12 June 2024

Neil McBride
Head of Planning
Planning Services
Lincolnshire County Council
County Offices
Newland
Lincoln LN1 1YL
Tel: [REDACTED]
E-Mail: [REDACTED] lincolnshire.gov.uk

**Planning Act 2008 (as amended) – Section 55
Application by GTR4 Ltd for a Development Consent Order for Outer Dowsing Offshore Wind
(Generating Station) – Relevant Representations**

**HAUL ROAD CROSSING 04 -
INGOLDMELLS ROAD**
SCALE 1:500

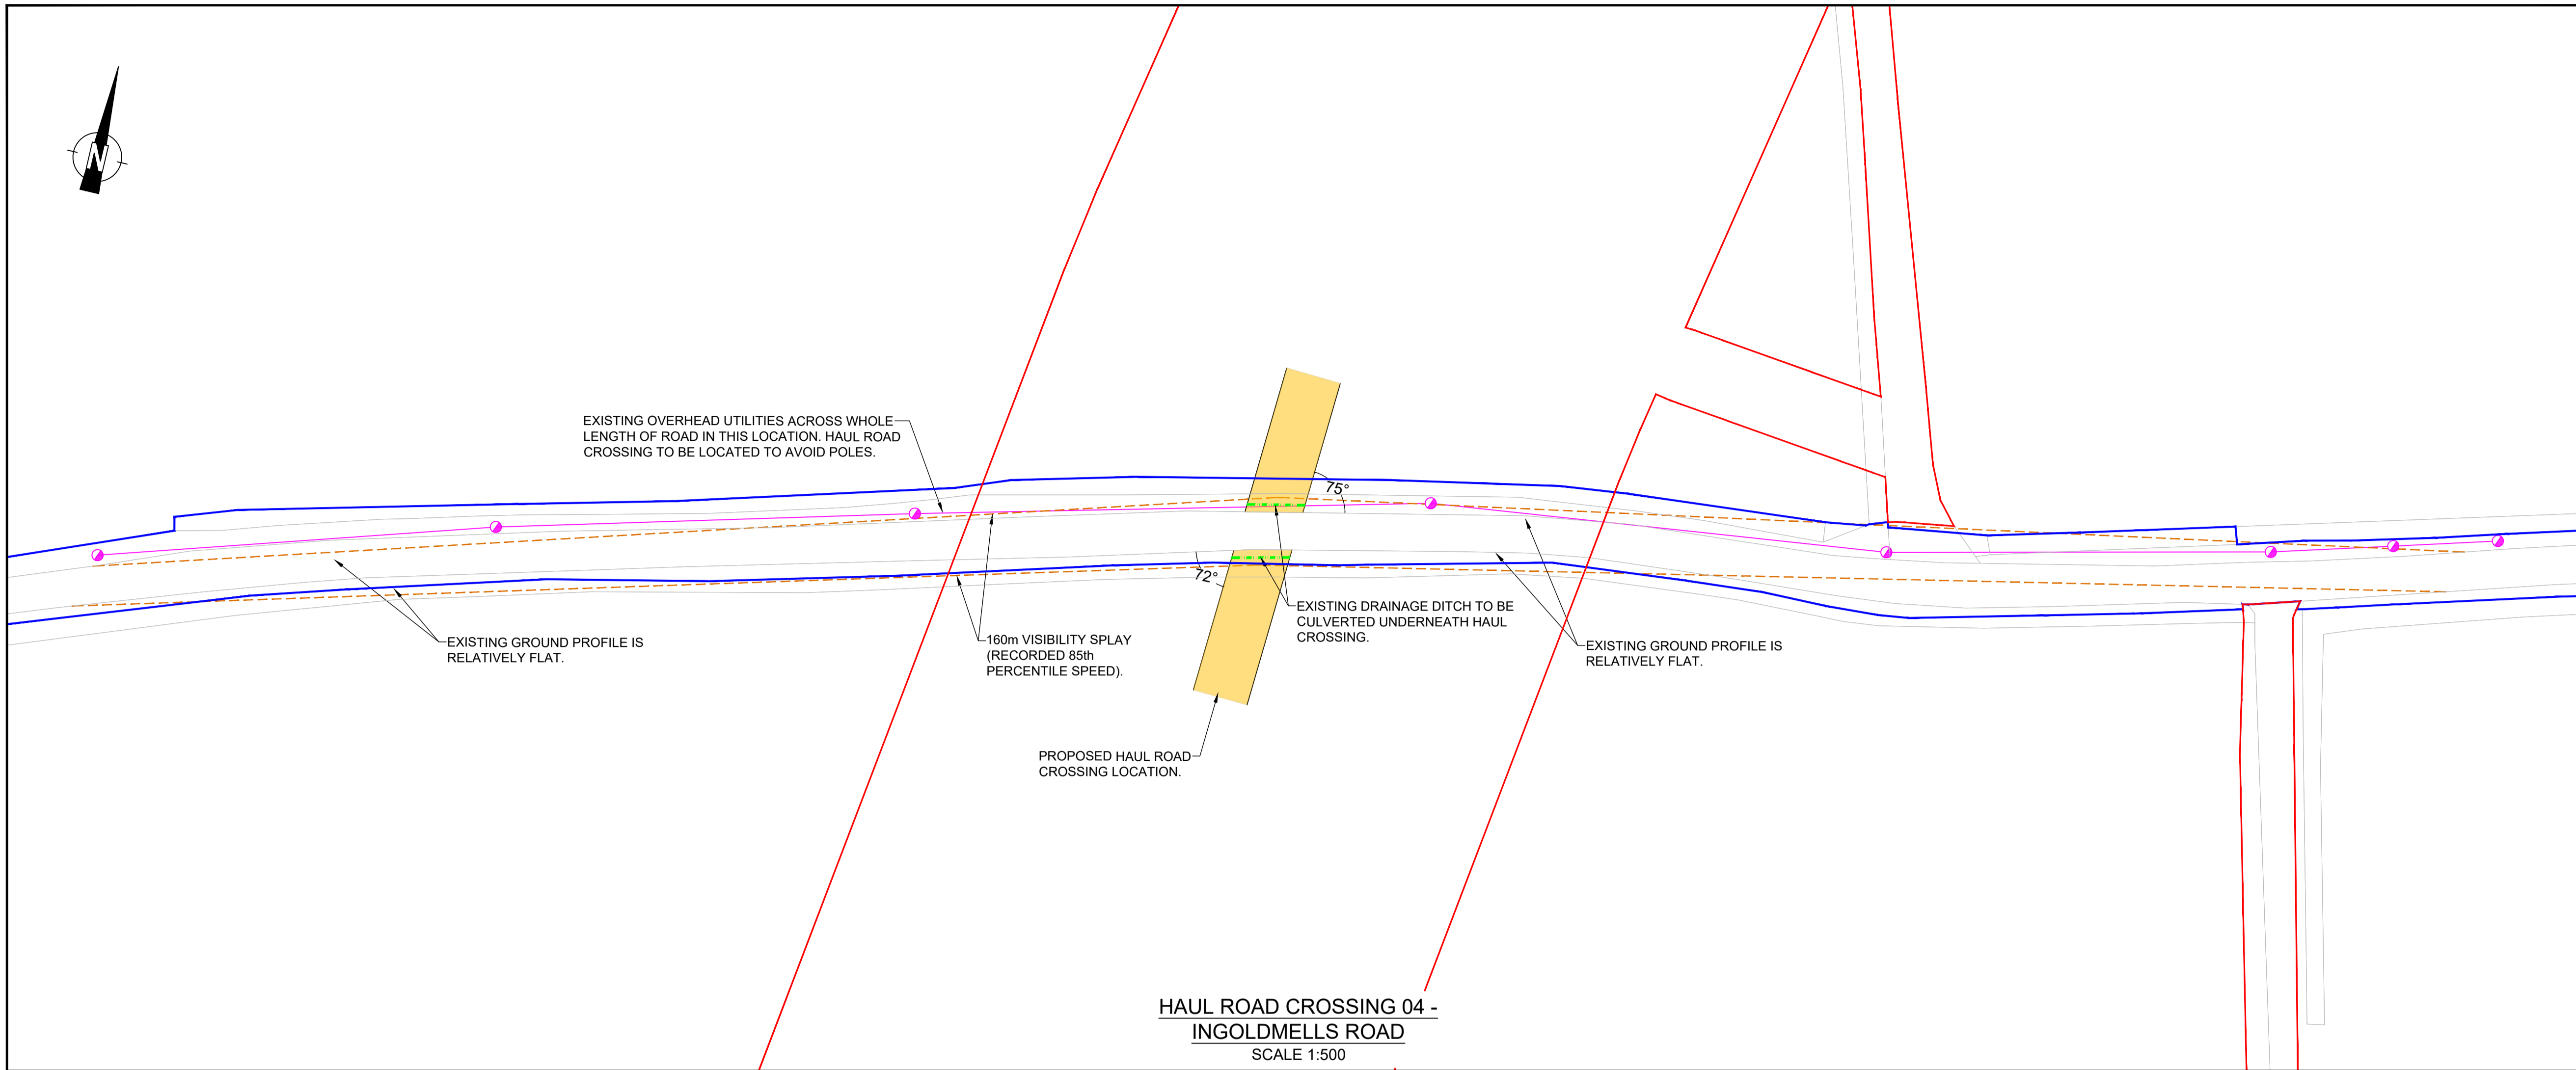
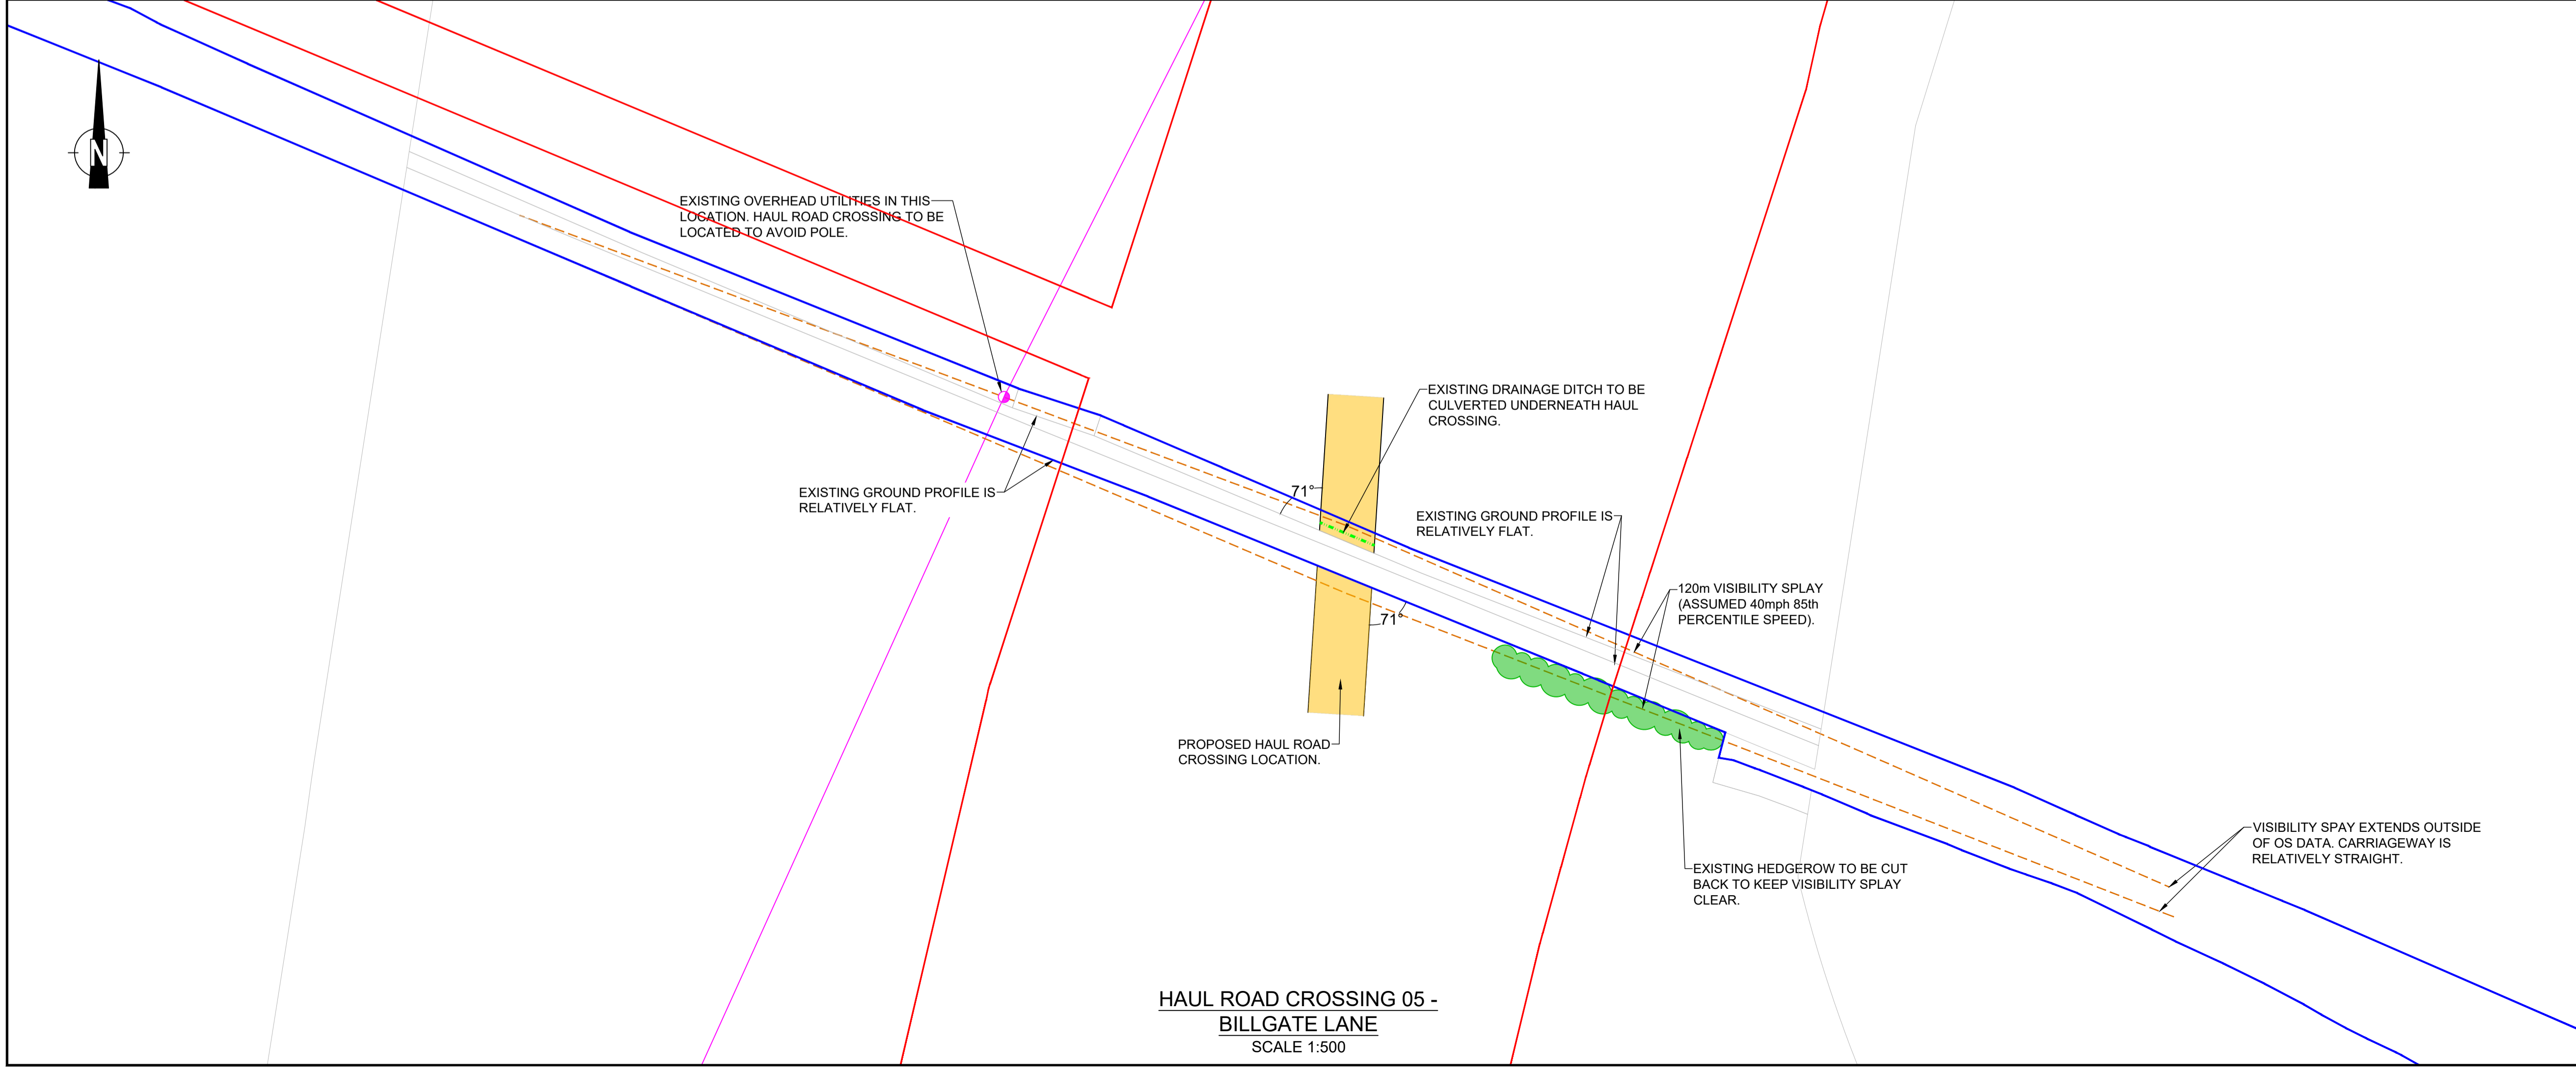
Para 93 lists roads to be crossed using trenchless technique, LCC considers this should also include other roads such as Ingoldmells Road, Sloothby High Lane, South Ings Road and Marsh Lane, as all of these roads have reasonable levels of existing traffic. Other roads may also need to be crossed by trenchless technique, the final list will depend on the traffic management and construction issues yet to be considered in detail, but discussed in the Outline Construction Traffic Management Plan (OCTMP) paras 49-56.
